Modification Report No.5

Tweed Valley Hospital SSD-10353: Changes to Multi-deck Carpark

Project Summary Tweed Valley Hospital – Modification to Stage 2 Consent and Approved Plans

DRAWING TITLE
FLOOR PLAN - GROUND

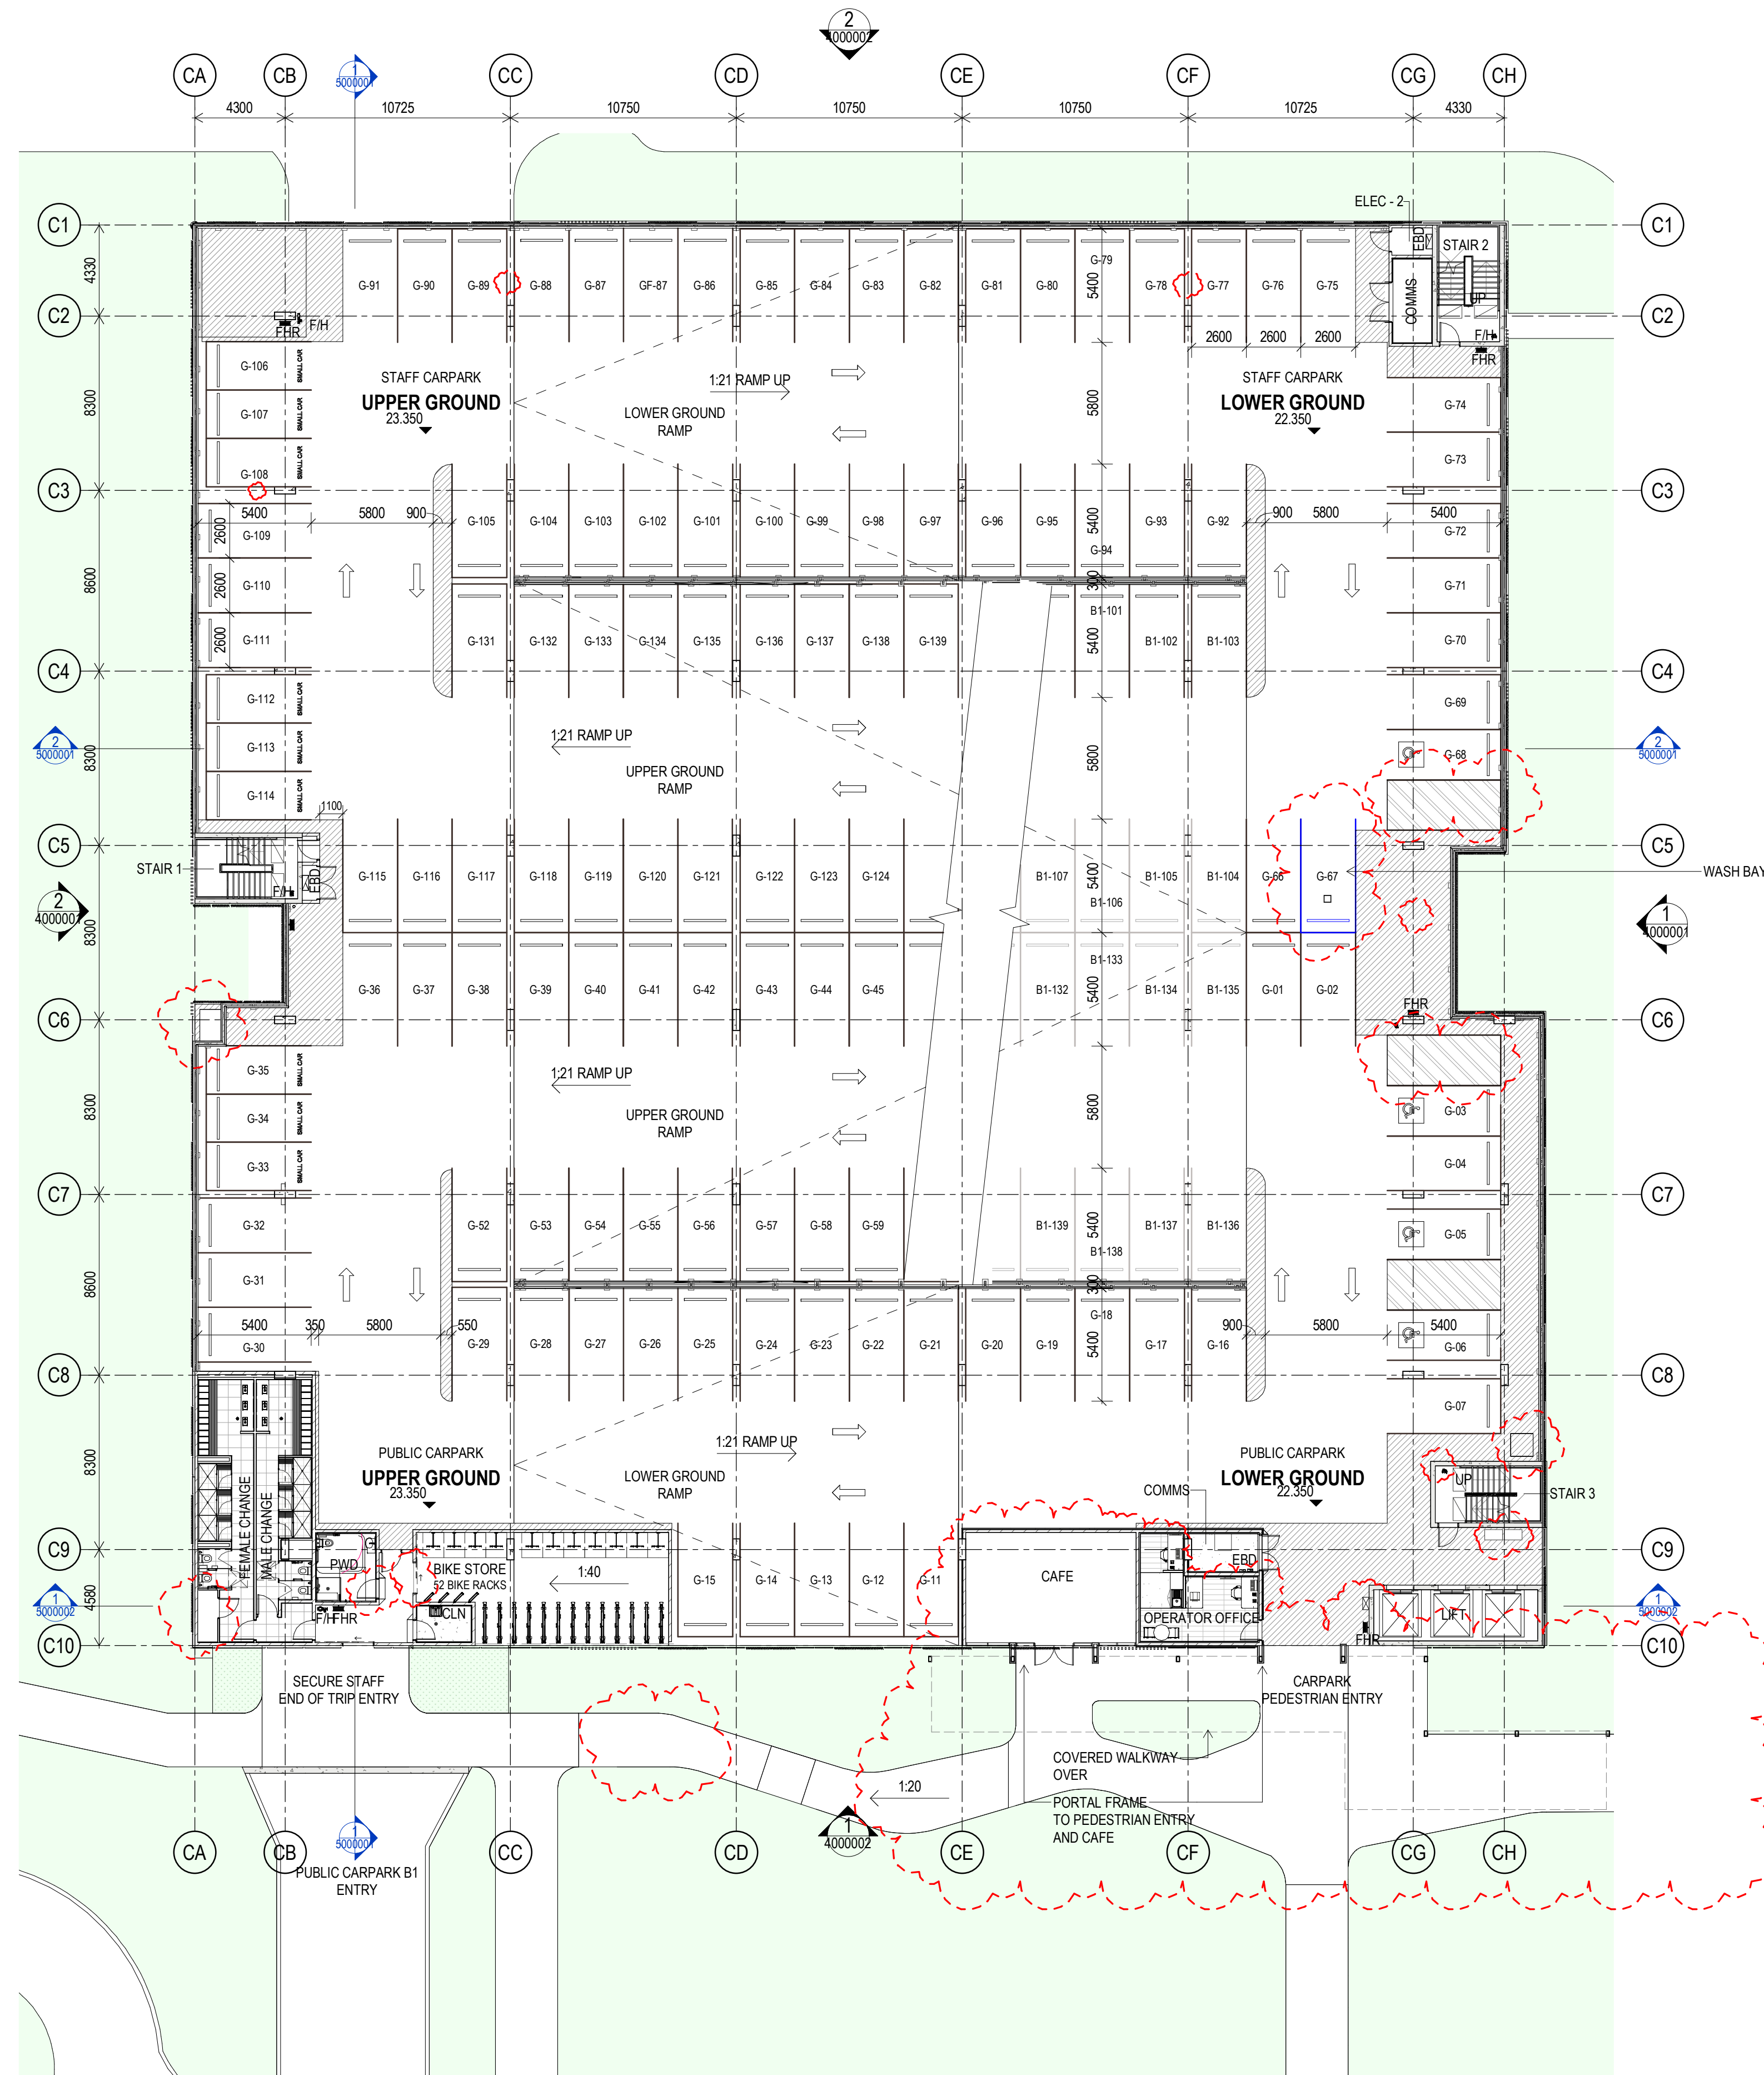
- wash bay and drain added to a single staff parking space (G-67), with no change to the general function, operation and car parking space availability

3.1.3 Café tenancy space added to ground floor and associated removal of three parking spaces

A café tenancy has been proposed on the ground floor of the multi-deck car park, adjacent to the Operator's Office. The inclusion of this space results in removal/deletion of three (3) parking bays and extension of the covered walkway. This addition is intended to provide a basic food and drinks service to staff and visitors in proximity to the carpark as people arrive at or leave the hospital campus.

DRAWING TITLE			
FLOOR PLAN - LVL 03			
PROJECT No	21192	DRAWN Author	CHECKED Checker
ISSUE 08/09/2022 12:27:07 PM	SCALE @ A1 1:200	SCALE @ A3 1:200	REVISION
DRAWING No MDD-AR-SKE-MCP-2003001			4

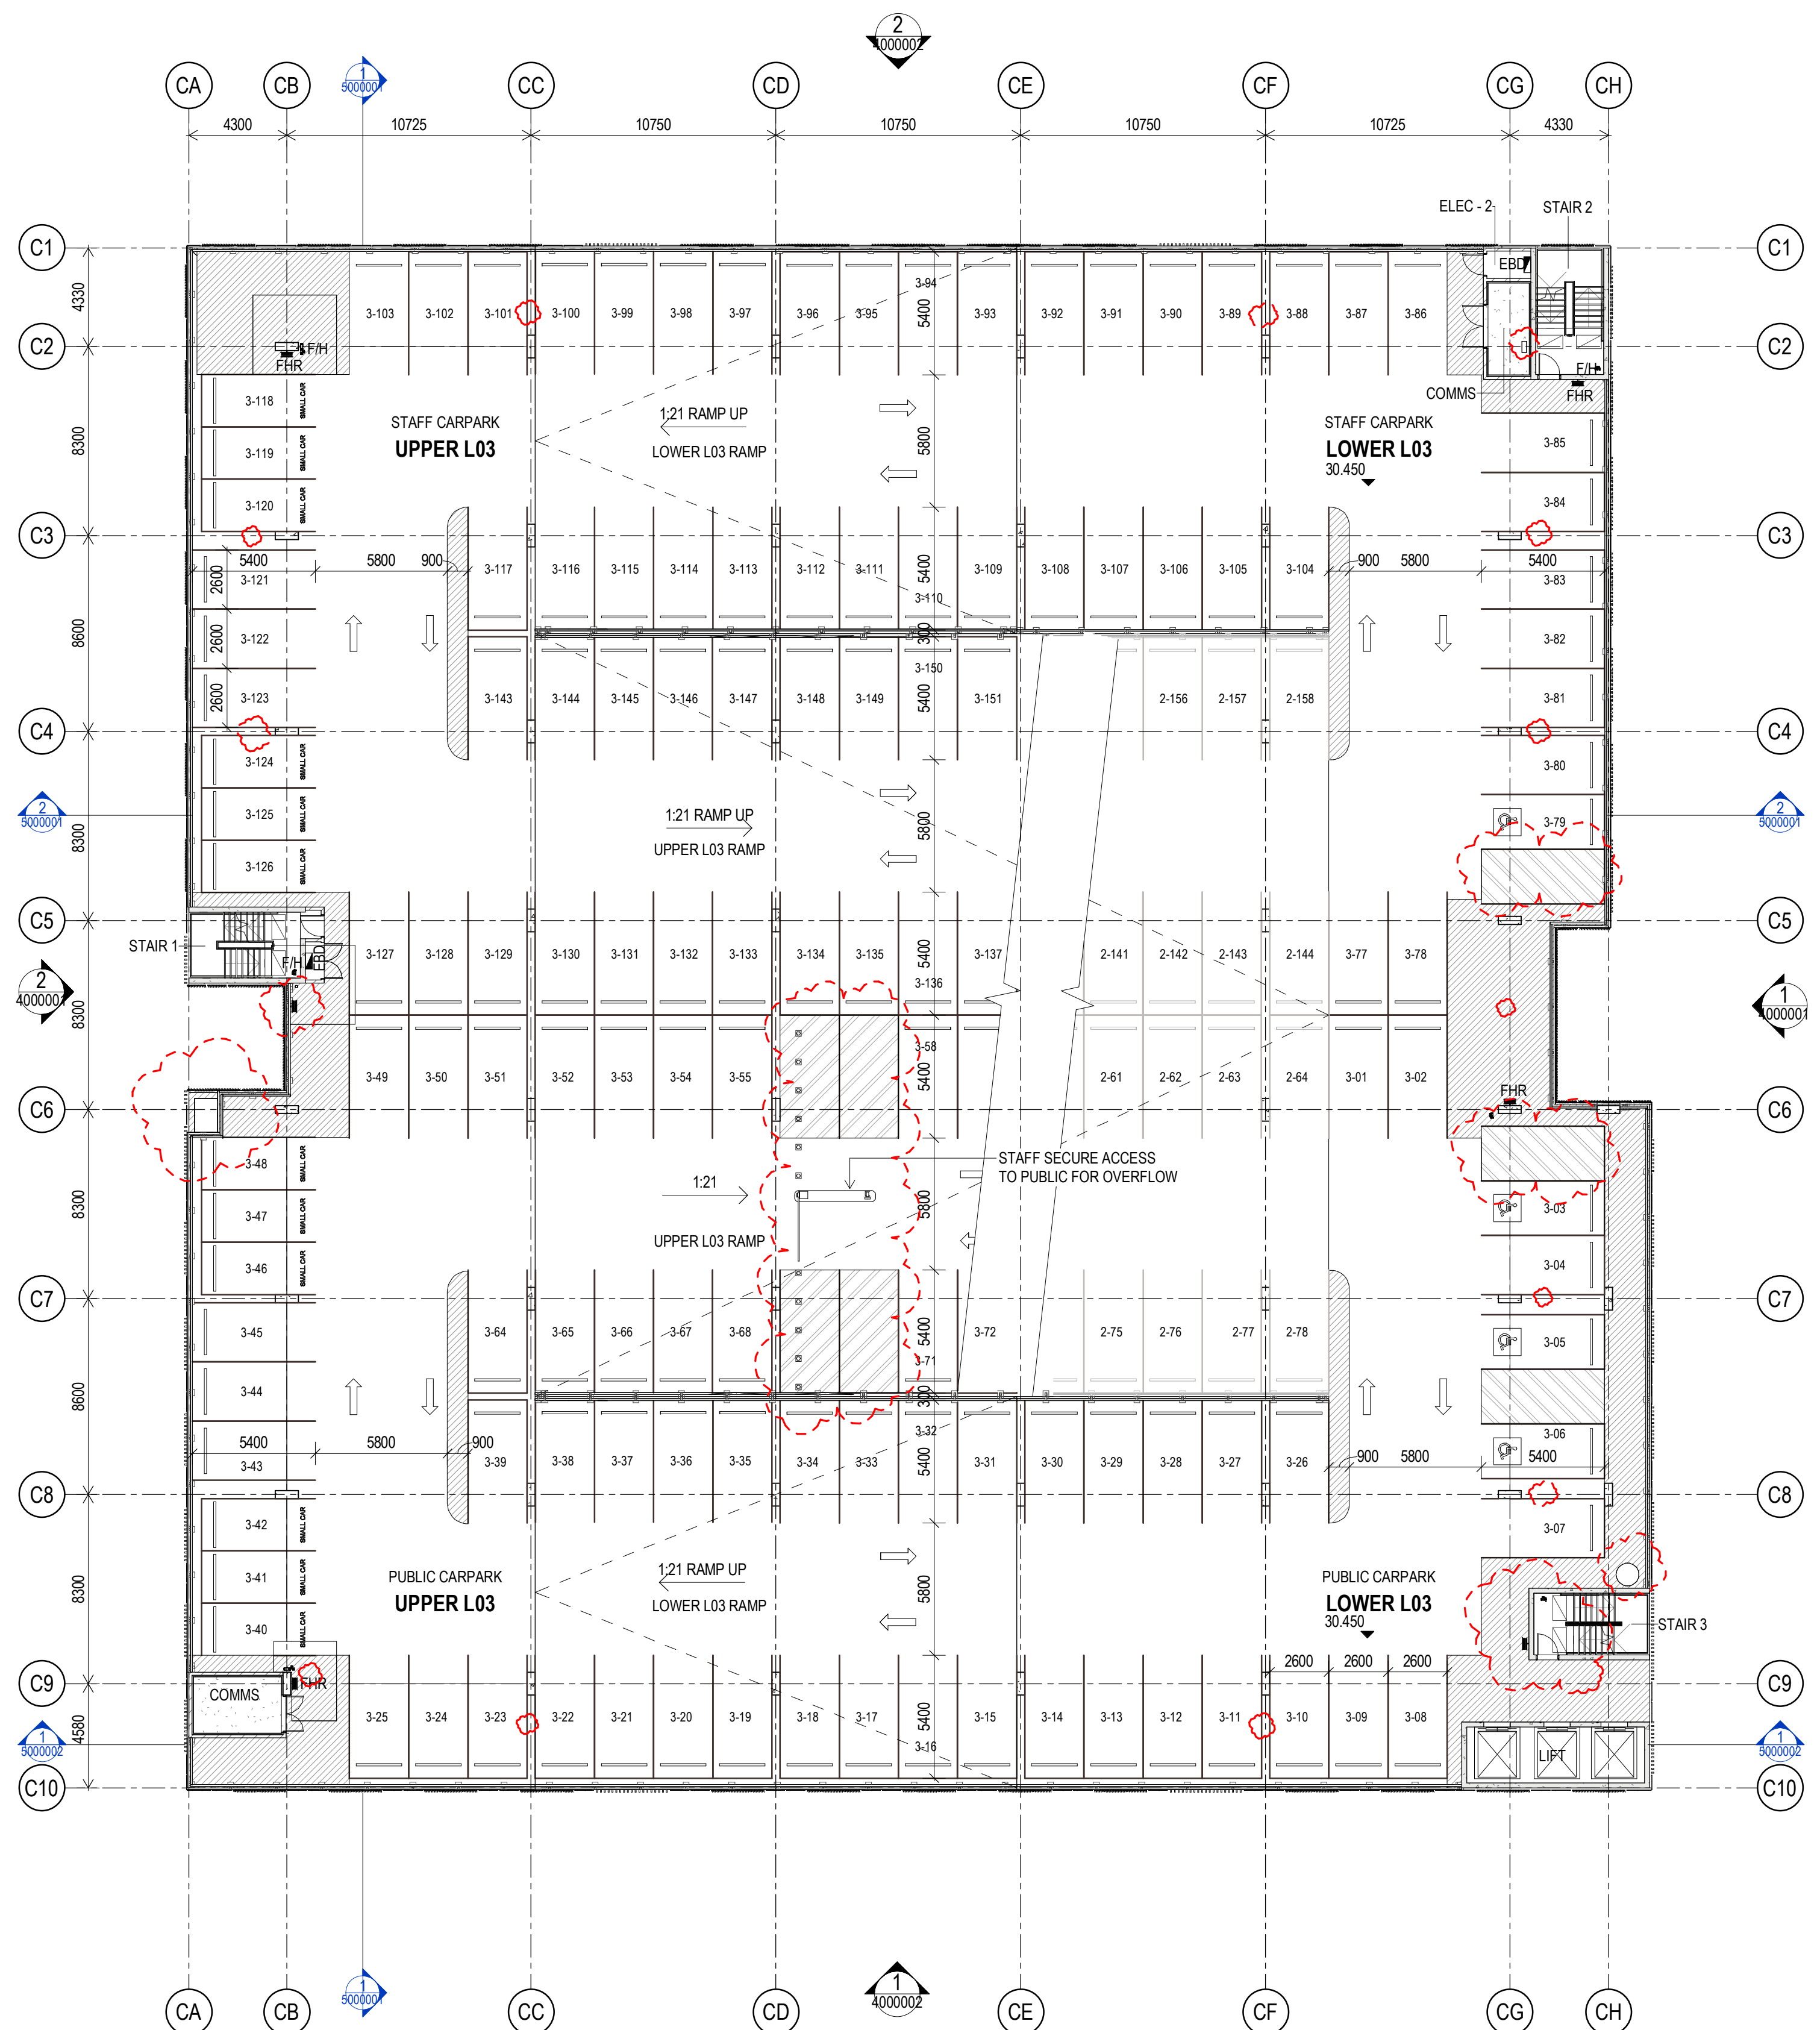
- relocated staff overflow boom gate/card reader and larger island on level 3 results in loss of a further two (2) car parking spaces, compared to the original approved arrangement on level 3.

DRAWING TITLE
FLOOR PLAN - LVL 04

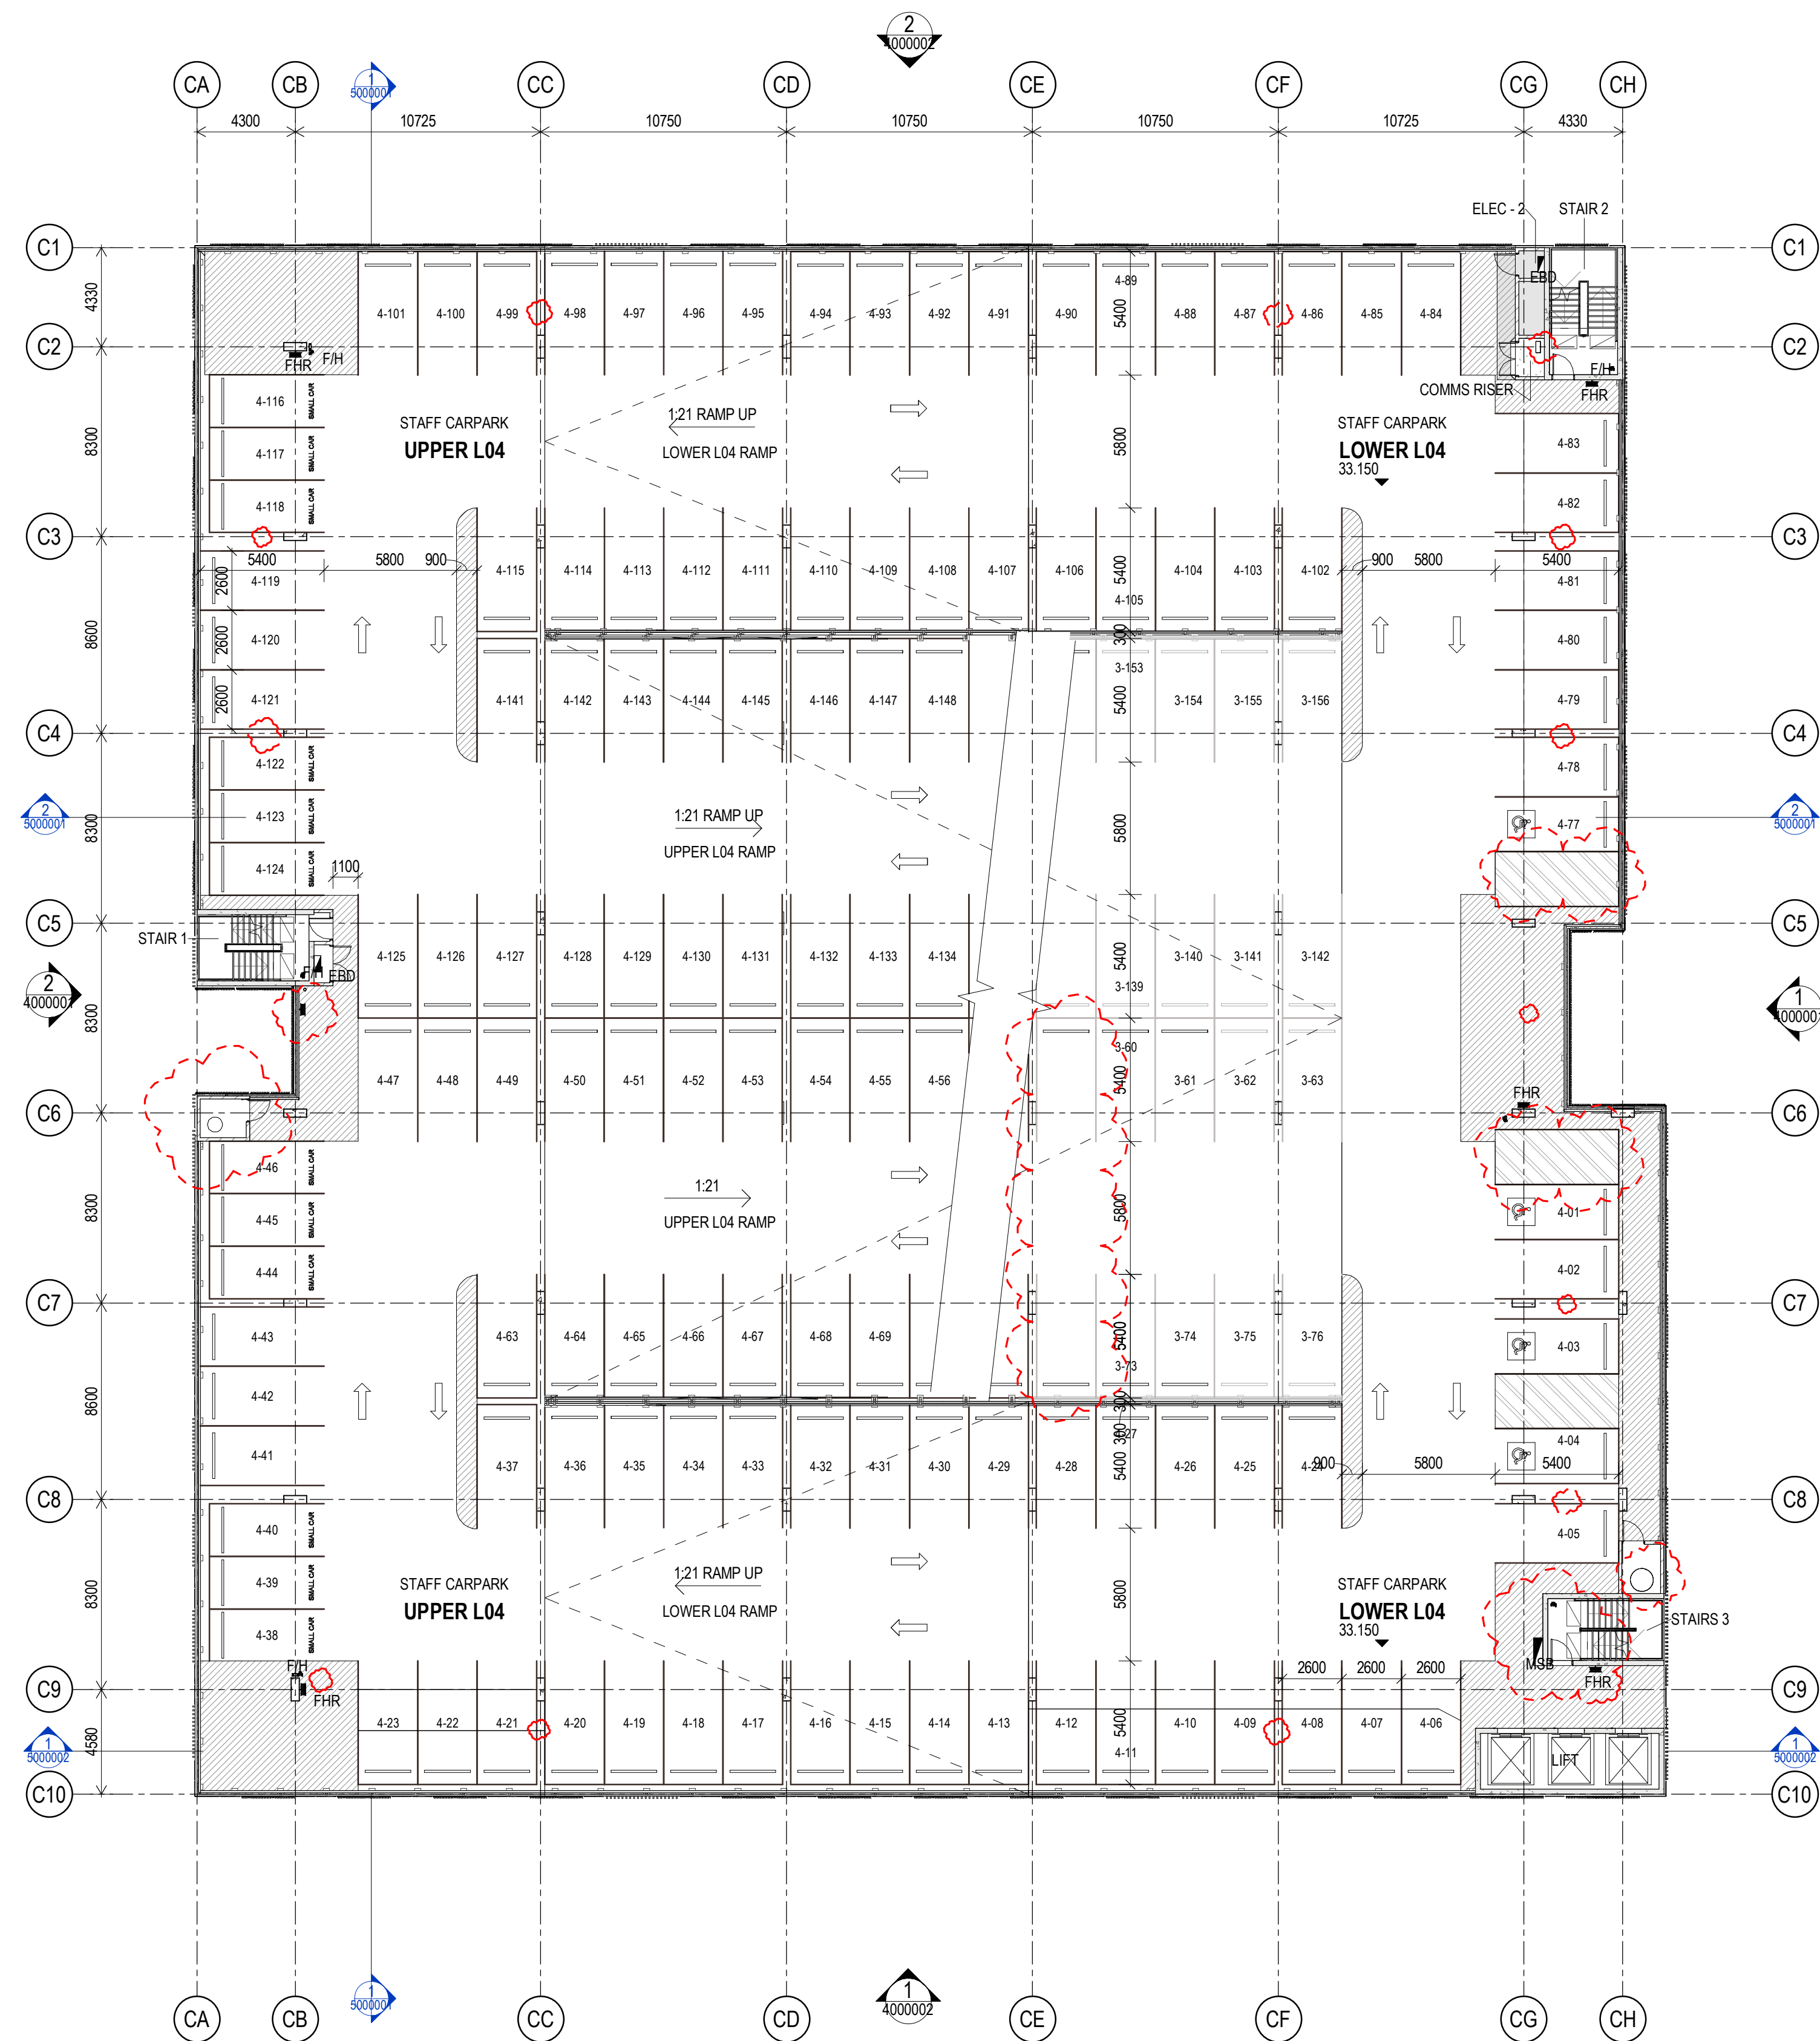
- layout of the car park management system equipment (boom gates, card readers etc) adjusted, including:
 - staff overflow boom gate moved from level 4 to 3 and two parking spaces reinstated on level 4 as a result
